Reference No: **2026/NM/90956/W**

Site Address: 16, Harvey Royd, Almondbury, Huddersfield, HD5 8SP

Description: Non material amendment to previous permission 2025/93149 for variation of condition 2 (plans) on previous permission 2024/92589 for erection of single and two storey side and rear extensions, with erection of dormers

DECISION – NON MATERIAL AMENDMENT APPROVED

PROPOSED REAR ELEVATION
SCALE 1:100 @ A1

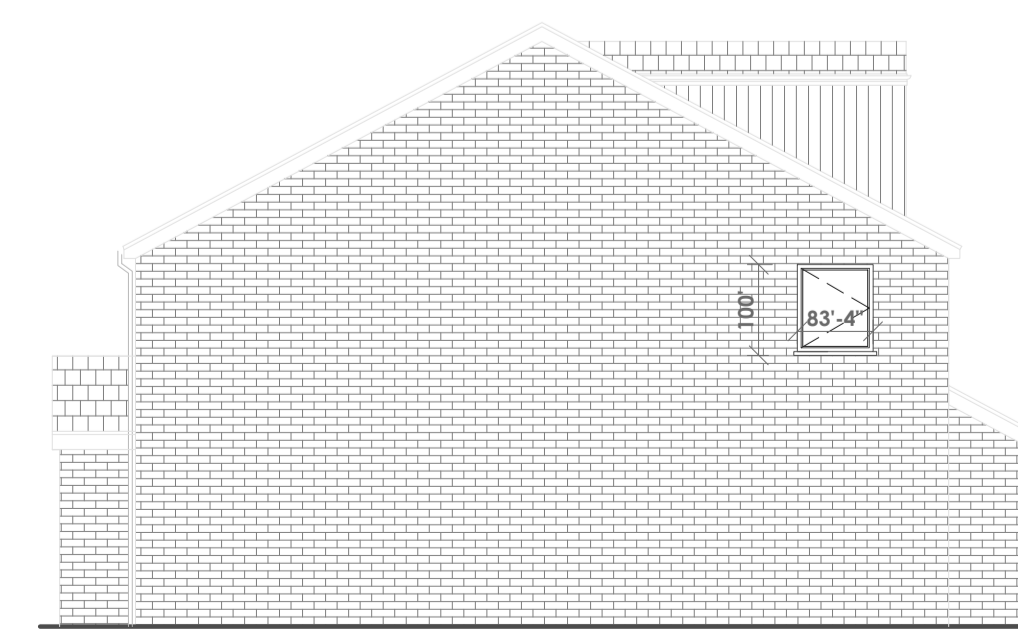
- Change the central first floor window in the rear elevation of the property to a door with fixed glazed balcony (Juliet balcony)

The amendment sought to change the central opening within first floor rear elevation of the property from a window to a door with fixed glazing (Juliet balcony) as shown on drawing number 2DIO-GA01 received by the Local Planning Authority on 7th April 2026 is considered acceptable as a non-material amendment to the approved scheme under planning reference numbers 2024/92589 and 2025/93149.
